From: Julie Baxter
Sent: 27 April 2023 13:35
To: Andrew Thompson
Subject: FW: 23/00173/OUT - Land South of Green Lane, Chesterton

Thank you for consulting the Landscape Team on the above proposal. Having looked over the submitted documents / plans I would like to suggest the following:

Overview of the Outline Application:

Figure 9: Zone of Visual Influence and Representative Views

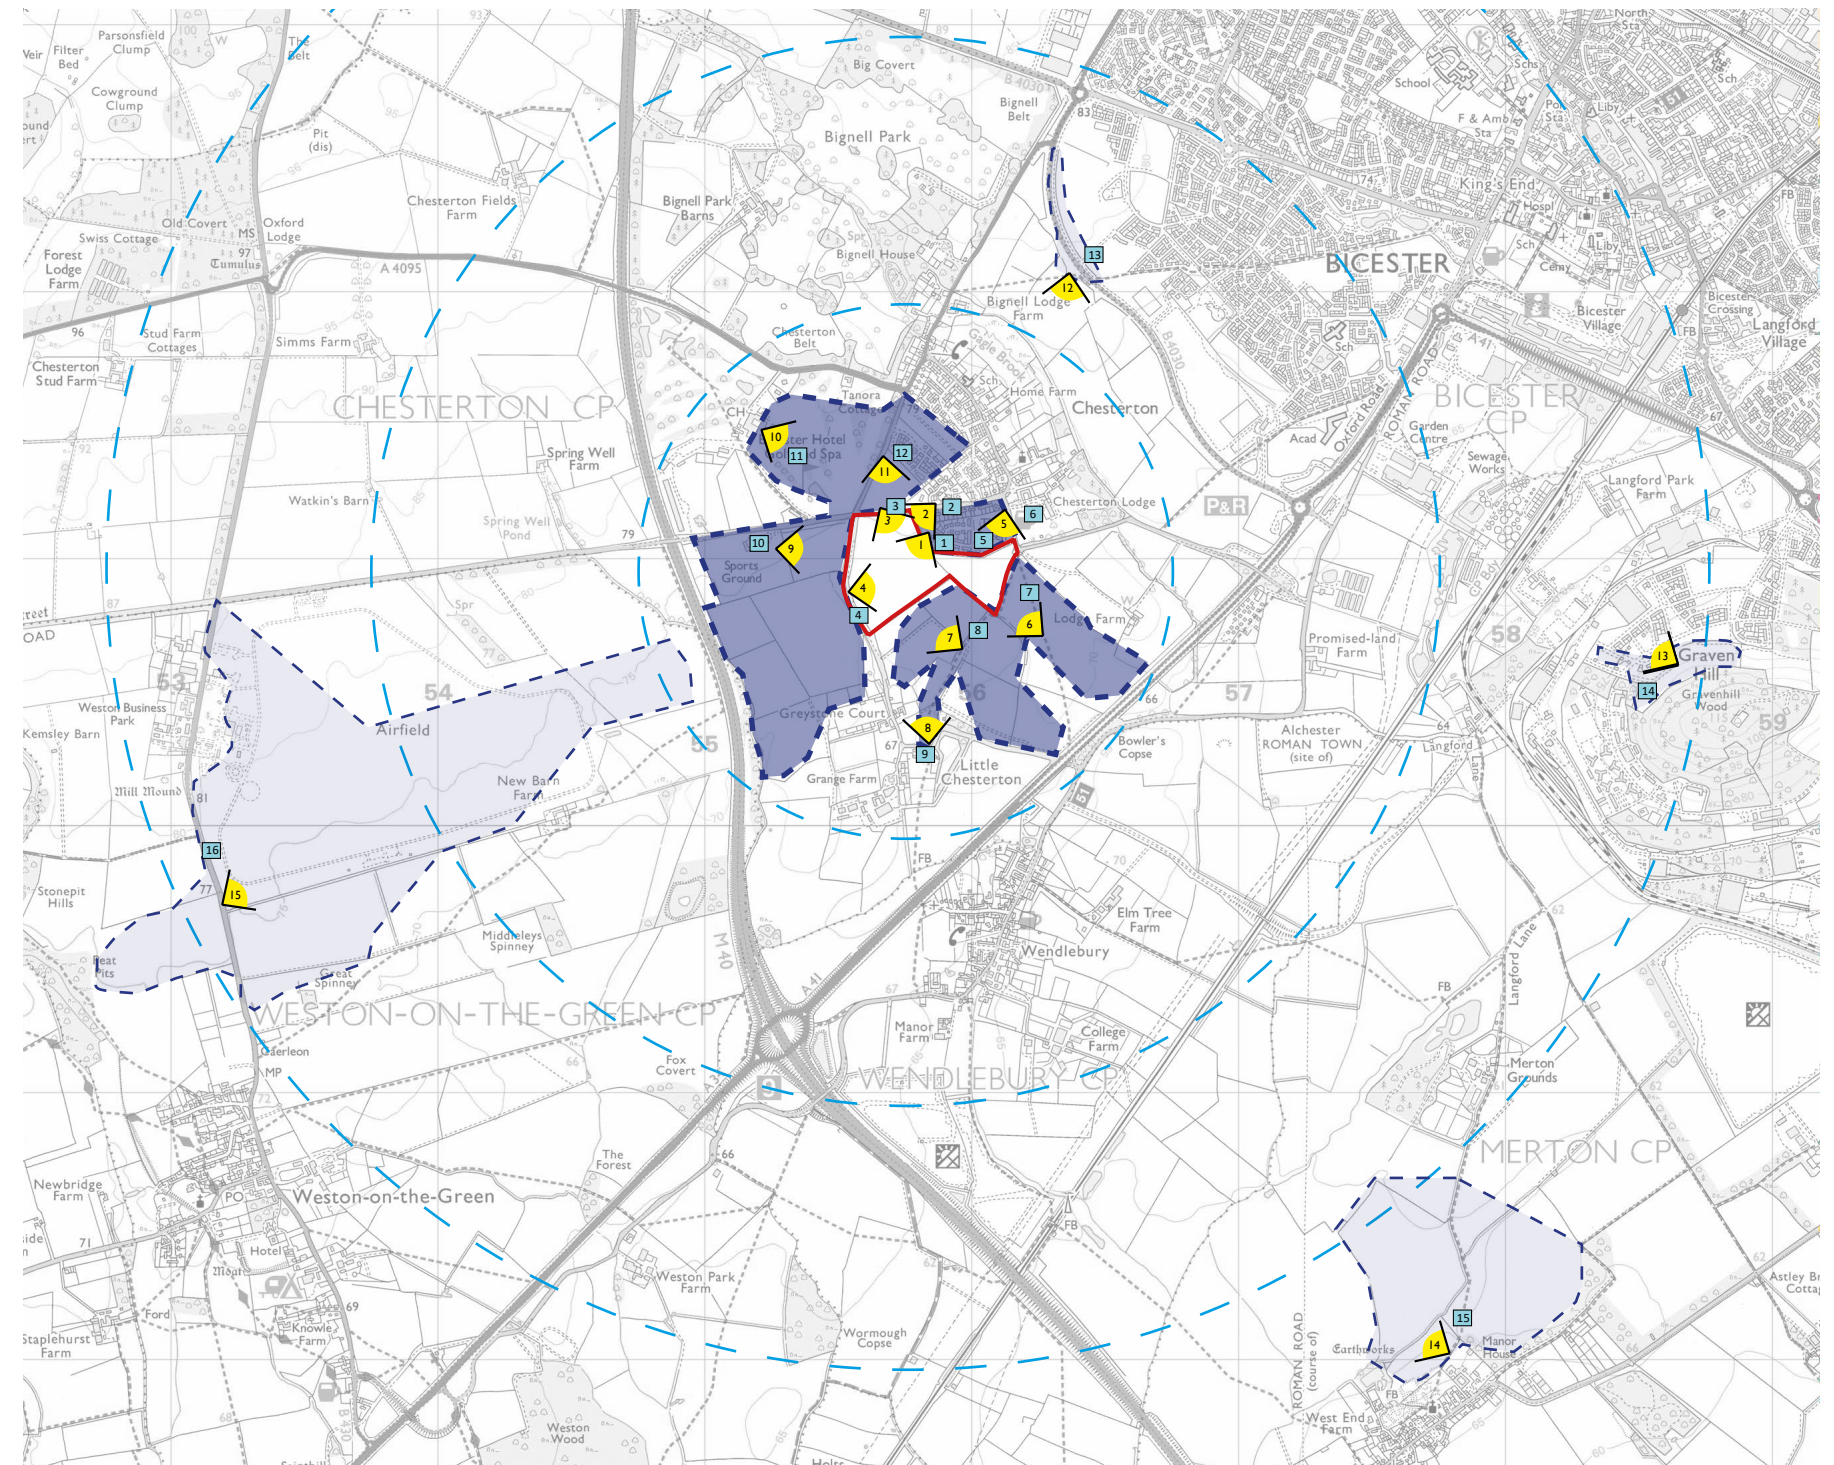
The LVA is comprehensive and proportionate and within the report a sufficient selection of viewpoints demonstrate the degree to which the Site and the proposals may be visible in the near, middle and longer distance views. The majority of views (VP 1-11) are contained to within 1km of the Site boundary. Beyond that the views are distant and filtered / obscured by intervening vegetation associated with the level landscape. These include: VP 12 which is within a 2km radius, VP 13 and 15 which are within a 3km radius and VP 14 which is within a 4km radius. Having

walked and driven several of the PRoW and connecting roads I confirm that the selected 15 representative views have incorporated the obvious elevated views whereby the development site may be seen.

I am in agreement with the LVA that the most sensitive Visual Receptors are those overlooking the Site at Vespasian Way, from Green Lane and walkers, cyclists, horse riders and motorists passing the Site on its northern and western boundaries. It seems that the majority of views are contained to within 1km of the Site boundary. Beyond that the views are distant and filtered / obscured by intervening vegetation associated with the level landscape. Of the 16 Visual Receptors, 7-16 are seen as having a Poor View of the Site, with a Low - Medium Susceptibility of Change, of Moderate Value and Low - Moderate Sensitivity of VR. However VR 1, 2 and 5 have a High Susceptibility of Change and with a High Sensitivity of VR.

VIEW 1 (continued)

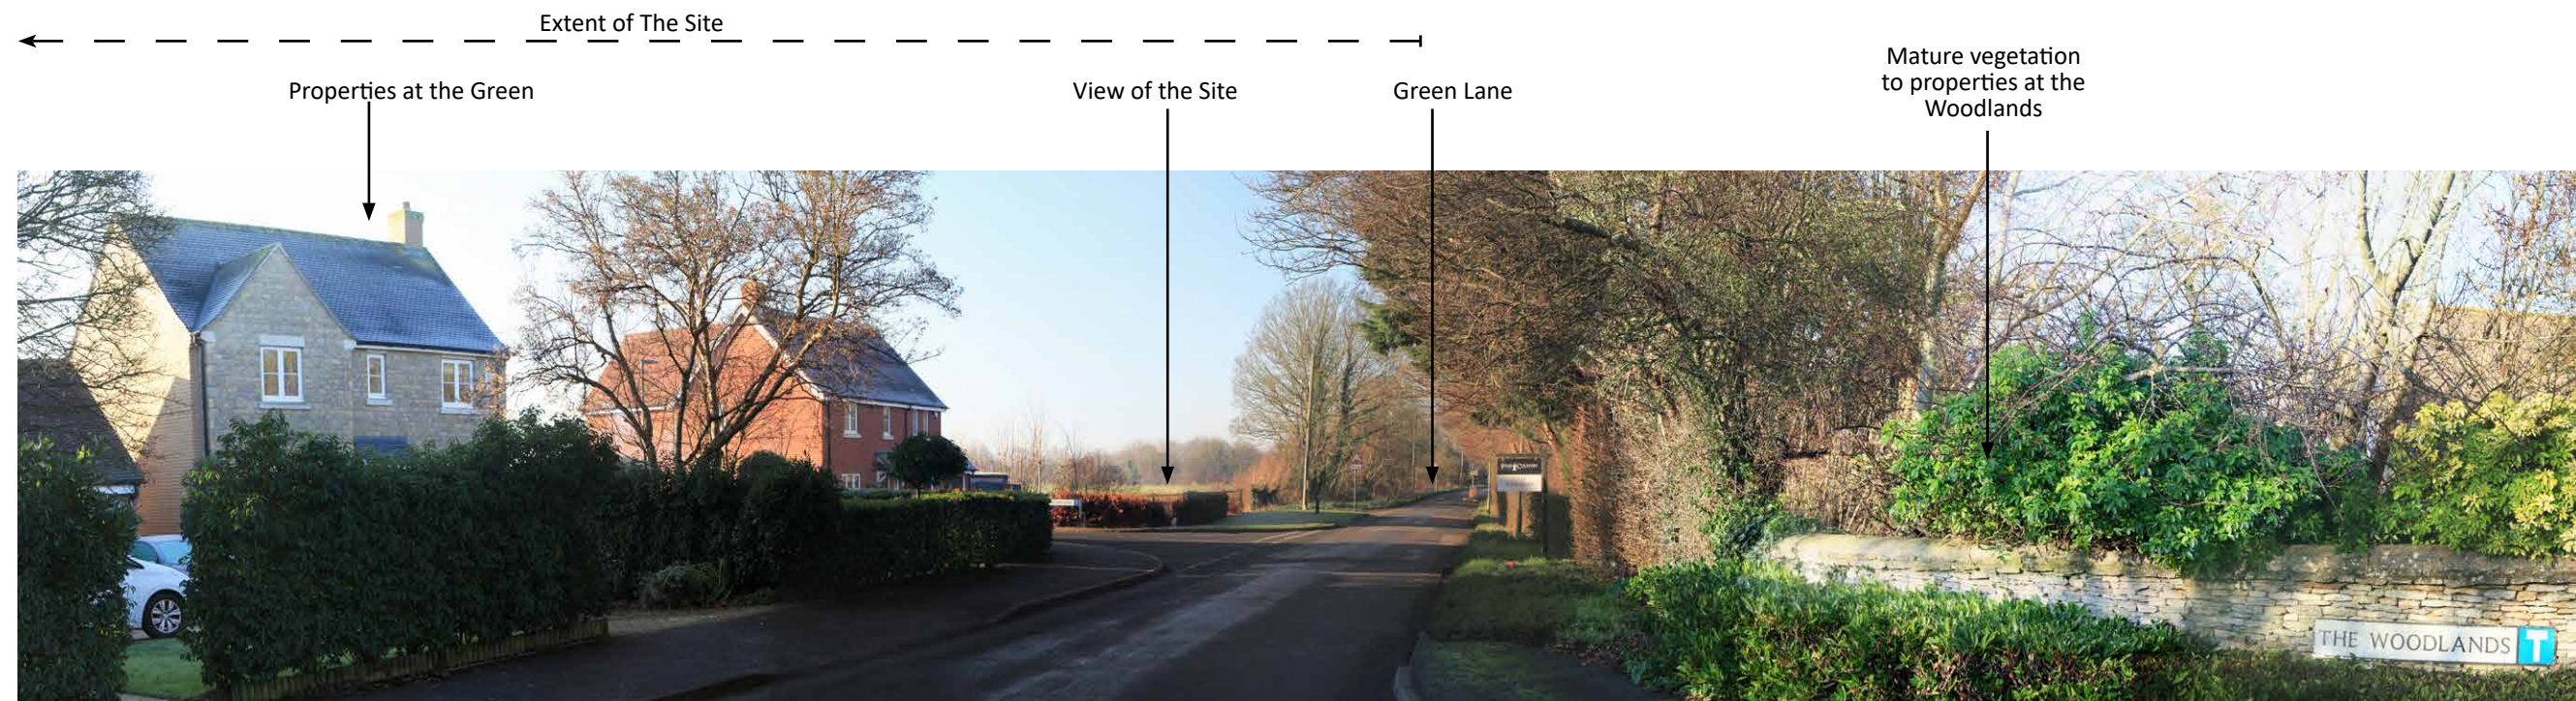
View 1 from Vespasian Way, looking south. The site will initially be in full view at this point. Screening will eventually lessen the impact in summer.

VIEW 2: View from Green Lane, adjacent to the Green.

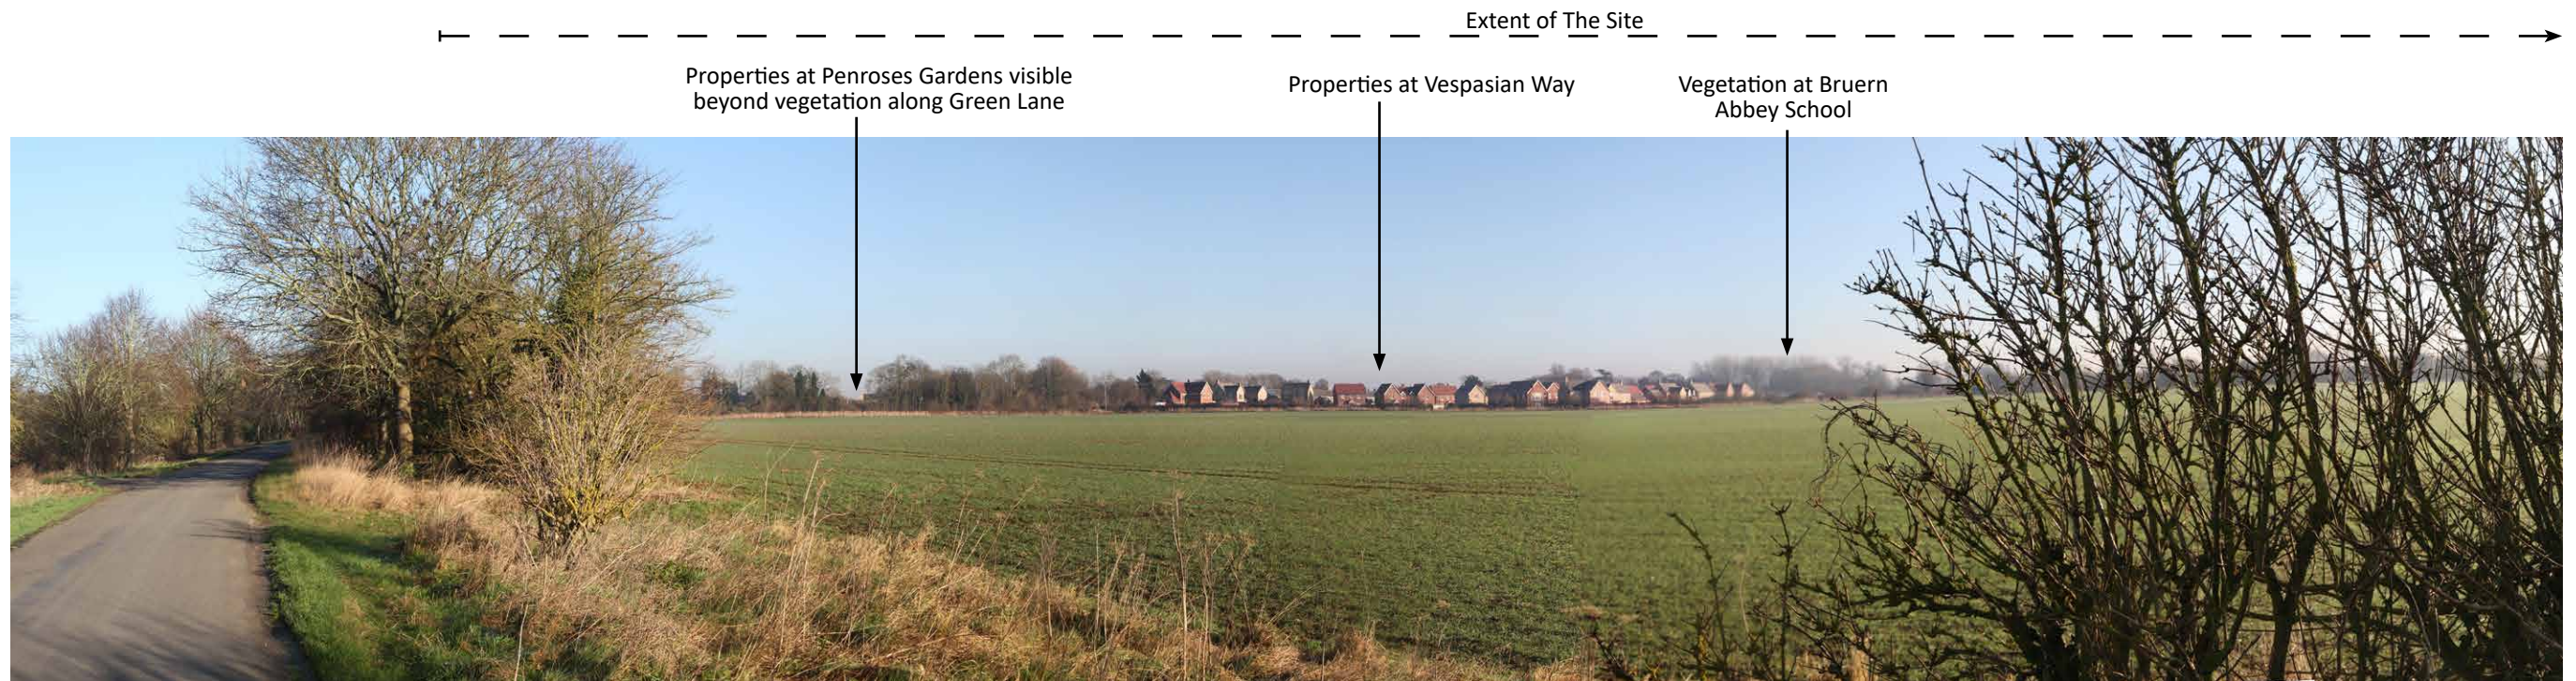
View 2 from Green Lane, adjacent to The Woodlands. Due to the lack of vegetation to the NE boundary, residents and pedestrians will have clear views of the dwellings on the development.
